**TOWER 2, LEVEL 23
DARLING PARK, 201 SUSSEX ST
SYDNEY NSW 2000**

RESPONSE TO REQUEST FOR INFORMATION - PRESTONS SSD 7155 MOD 2

The attached documentation and the table within this letter responds to the request for additional information and agency comments regarding the Section 96(1A) application (SSD 7155 MOD2).

EAST ELEVATION  
WAREHOUSE 4 - SPORTS CENTRE  
1: 300 scale

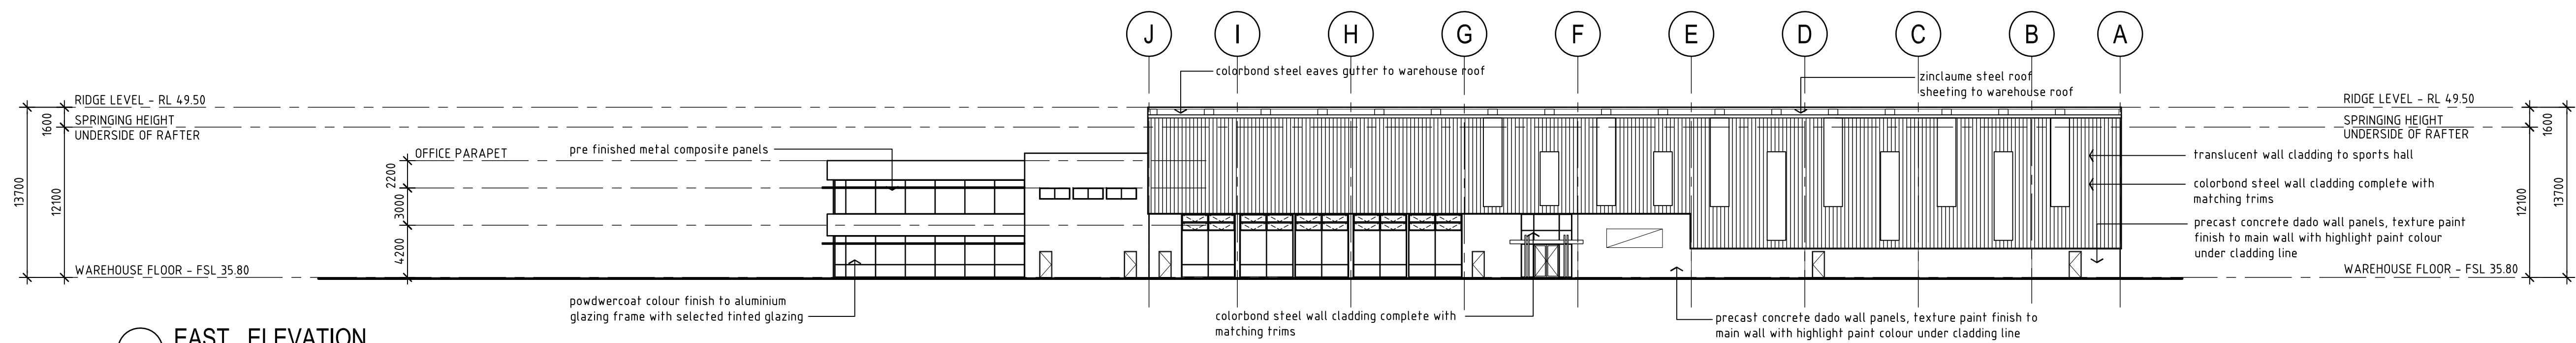
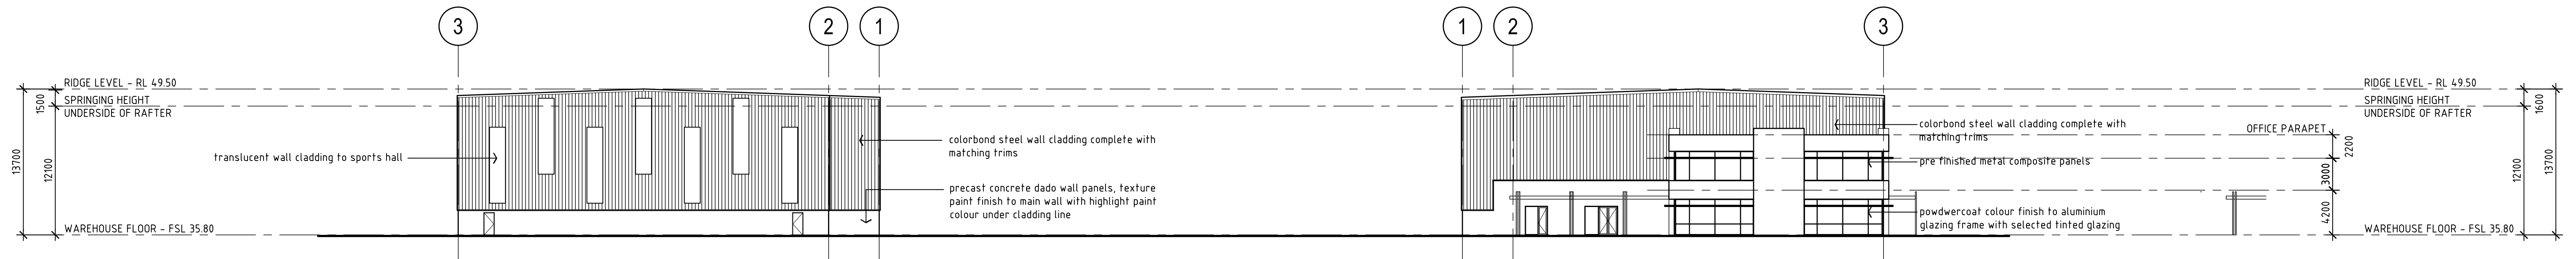
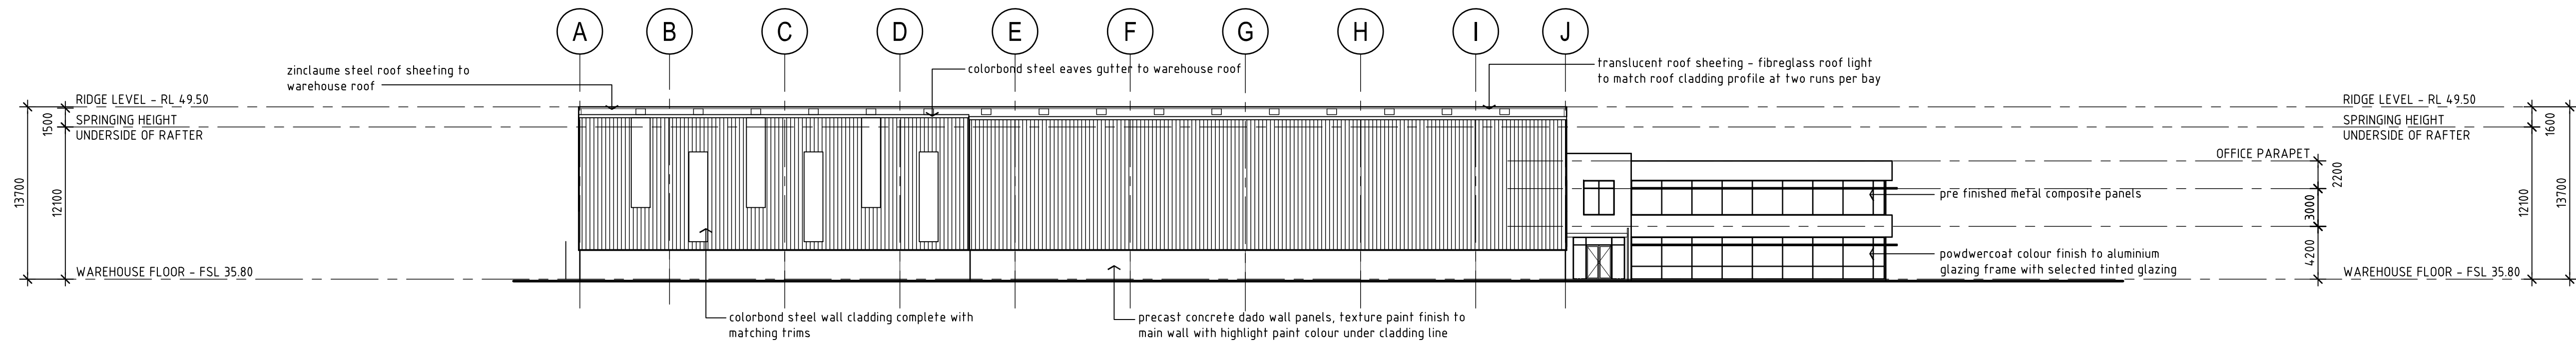
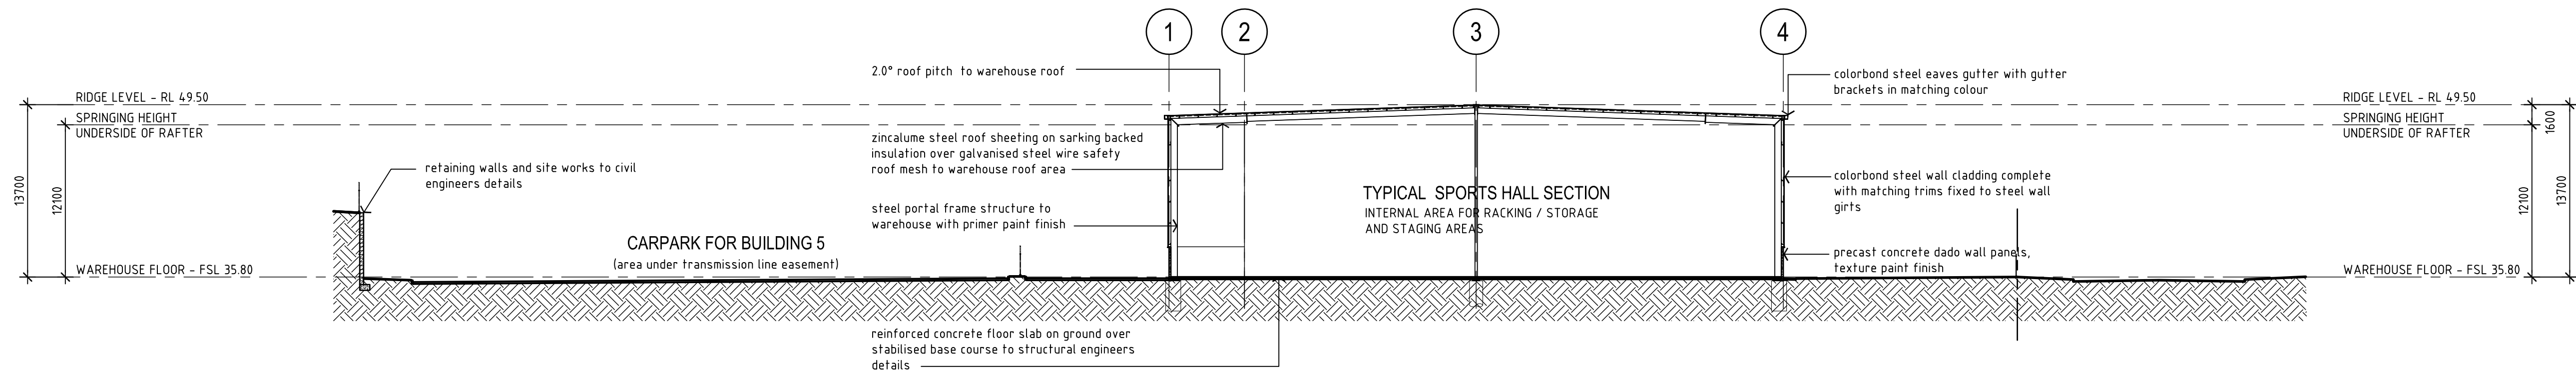
Submission	Response
Department of Planning and Environment	
<p>It is noted the landscaping section adjacent to Warehouse 4 along Bernera Road will be reduced from 6 metres to 2 metres in width.</p> <p>Please provide a detailed plan of the proposed landscaping along the Bernera Road frontage of Warehouse 4 which shows the height of tree species to be planted along this frontage of the site.</p> <p>Please also provide justification for the reduction in landscaping and an assessment of visual impacts on the Bernera Road streetscape.</p>	<p>Refer to the amended Landscape Package which shows the proposed planting detail on Bernera Road. The east elevation indicates the potential height of the proposed Grey Box and Grey Gums at 2 and 10 year periods, which will grow to a significant height once established and partially screen the majority of the buildings.</p> <p>The reduced setback does not limit the ability of the proposed trees and plantings to screen the built form of Warehouse 4. The tree species have been selected to provide leaf coverage at different heights, as shown on the updated photomontage included within the amended plans and extracted below for reference.</p>

SITE PLAN  
1: 1200 scale

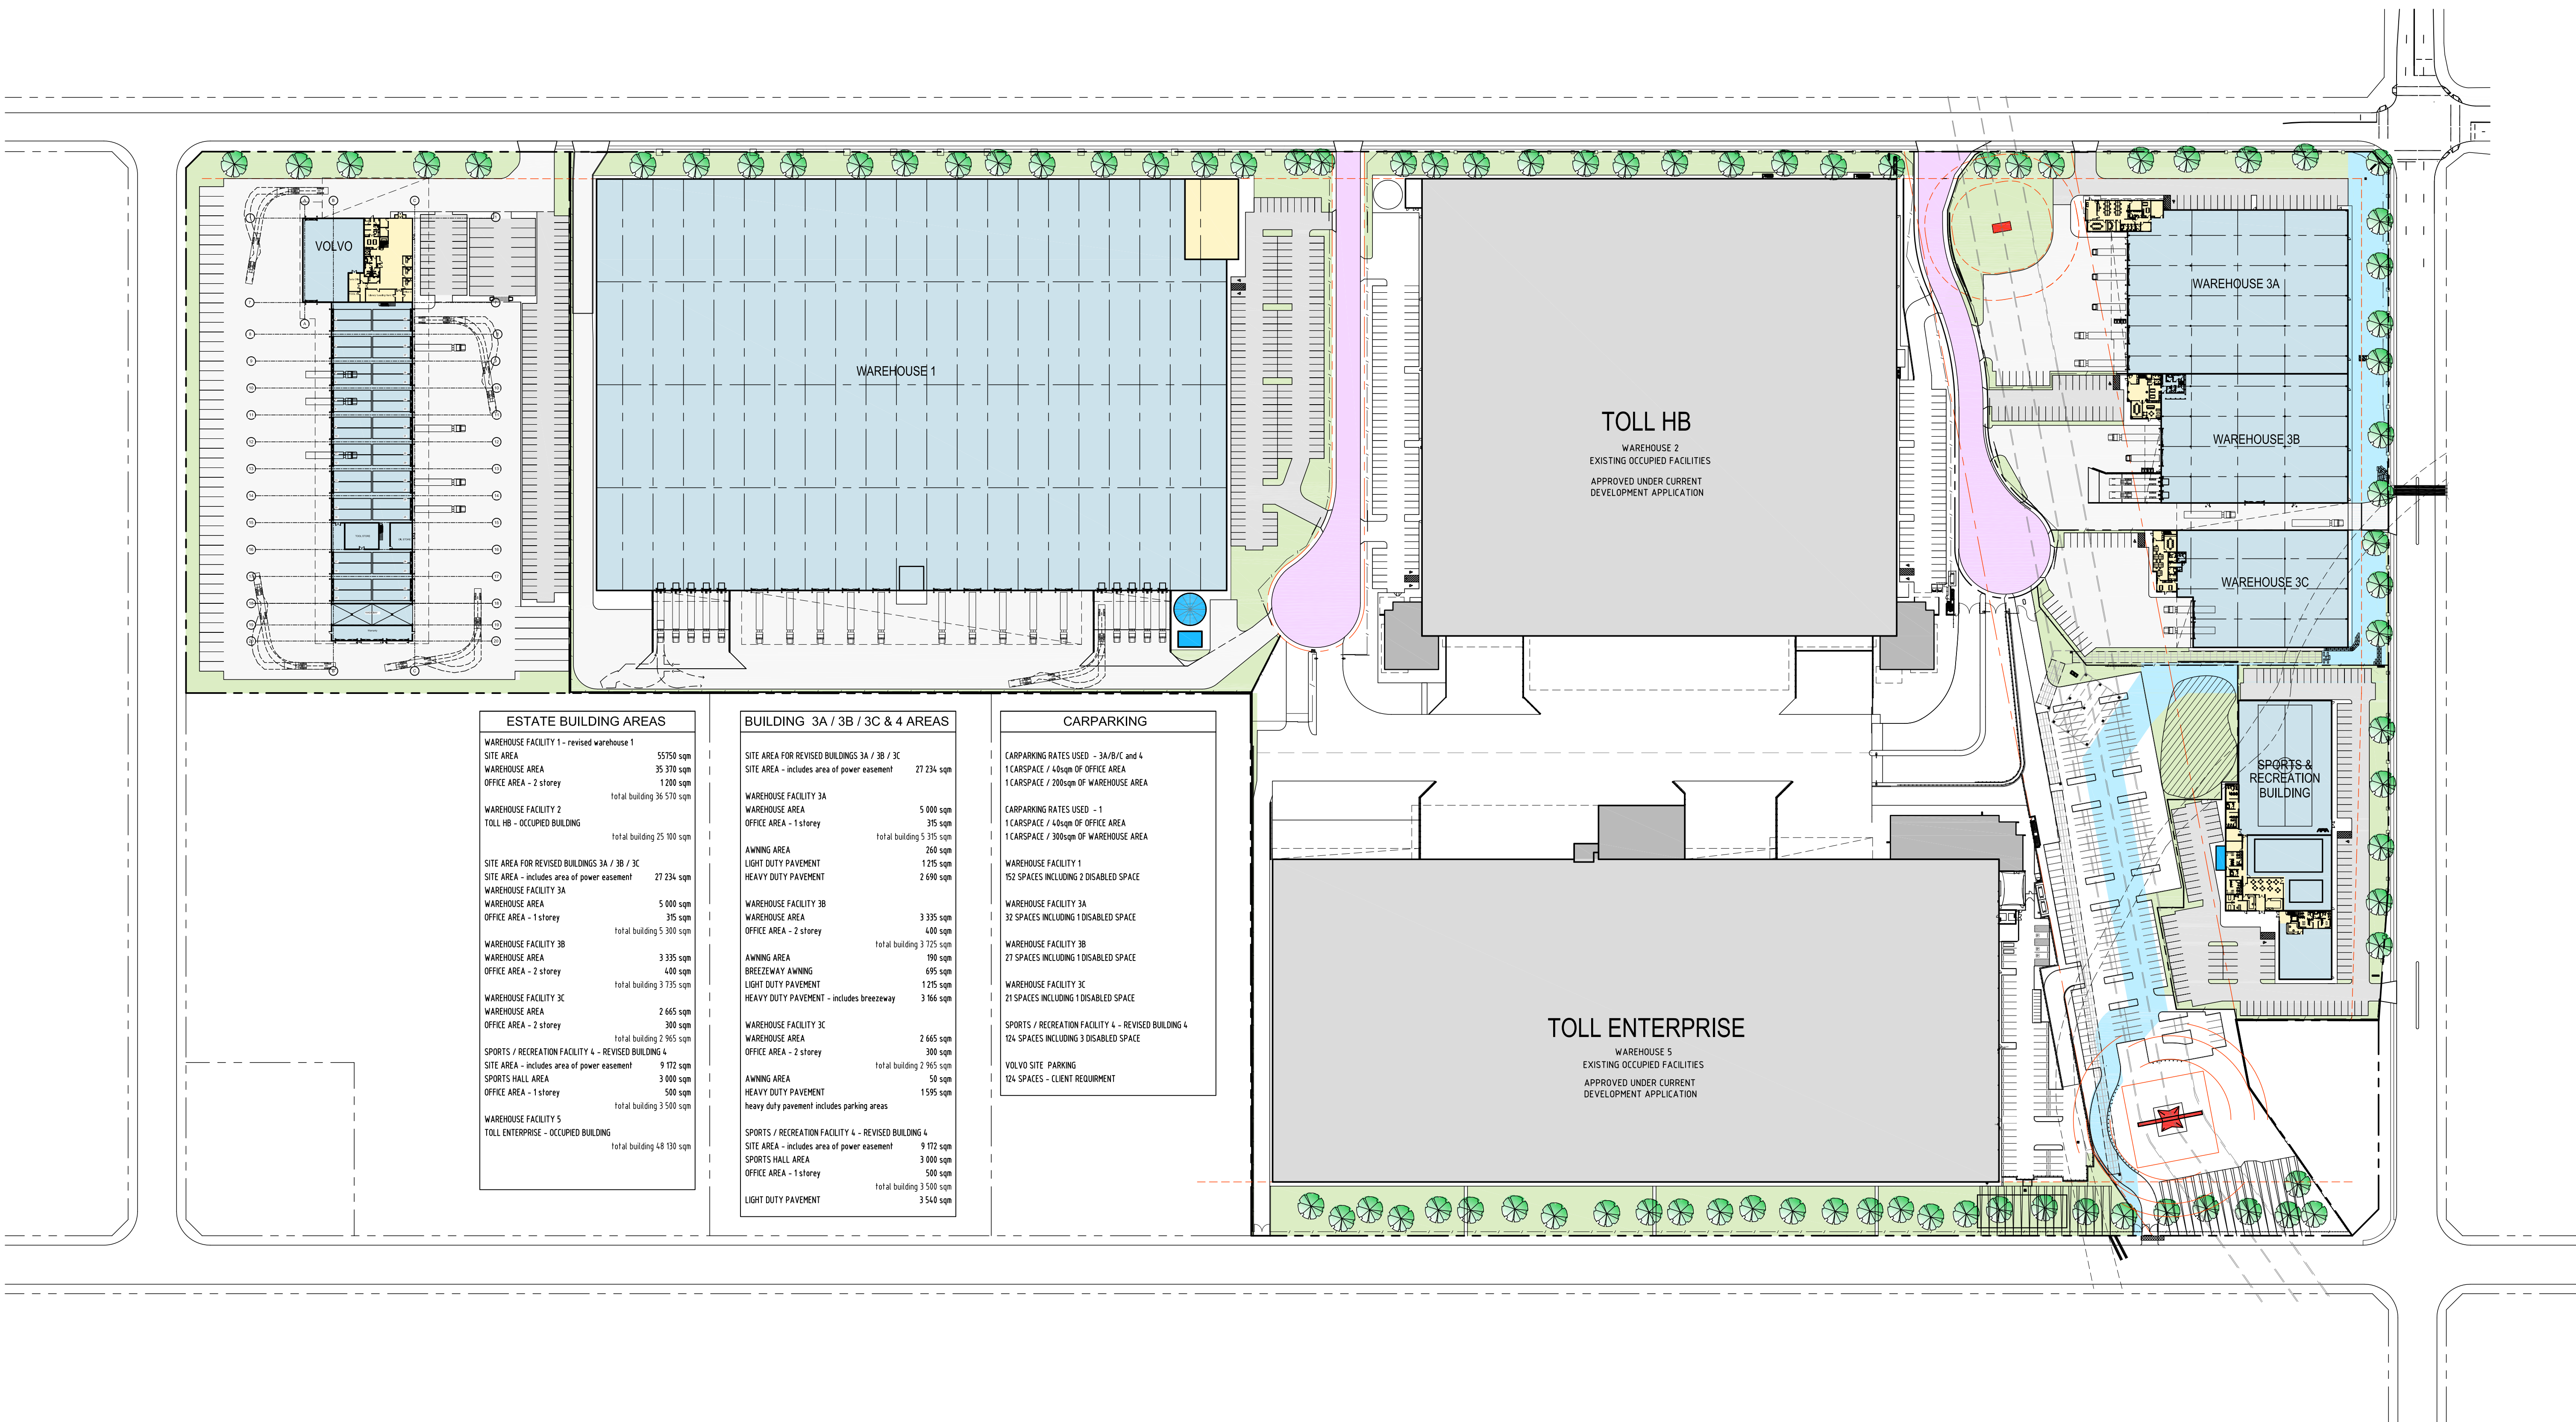
Transgrid	
<p>TransGrid requires that the applicant provides further details of any proposed amendments in TransGrid's easement that weren't part of the design approved by TransGrid in January (see approval attached). Any works proposed within the easement require a technical assessment by TransGrid to ensure that the required horizontal and vertical clearances to transmission lines and structures are met. TransGrid's clearance requirements must be met to ensure the</p>	<p>Transgrid access has been revised with direct access from Yarrunga Street. Both submitted architectural and landscaping plans show this arrangement.</p> <p>The Proponent we are complying with Transgrid requirements providing 15m clearance from the outside edge of the transmission tower legs (to top of batter). Transgrid had previously requested 1:8 batter from the 15m clearance line. Now that access has been provided from Yarrunga Street the batter on this side of the tower is not required. The proposal includes</p>

<p>safety of the public. TransGrid also needs to assess the impacts of the proposal on TransGrid's assets.</p> <p>TransGrid objects to this modification application as the landscaping works would interfere with TransGrid's access to the tower. The design of the area surrounding TransGrid's northern tower is unacceptable and is different to the previously approved design which was developed in consultation with TransGrid. The attached marked up drawing was previously provided by the applicant's representative in response to the issues raised by TransGrid. The original design would have prevented TransGrid from being able to access our towers and the proposed retaining wall was agreed to be shortened at the north-west corner of the property near the tower to allow us access.</p> <p>Access to TransGrid's transmission lines, stanchions and easement must be maintained at all times. Accessways/roads within the easement must be able to safely withstand the 40 tonne load capacity of TransGrid's maintenance vehicles.</p>	<p>significant quantum of battering to meet Transgrid requirements and any further will preclude the development on this lot due to loss of access and truck movements.</p> <p>Refer to revised Architectural Drawings</p>

- Revised Architectural Drawings, including a 6m wide lockable gate from Yarrunga Street for Transgrid access.
- Revised Landscape Drawings, including an updated photomontage indicating that the reduce landscape setback will not erode the ability to screen built form on Bernera Road.
- The architectural drawings are coordinated with the existing Civil DA drawings, with no change to the civil drawings required.
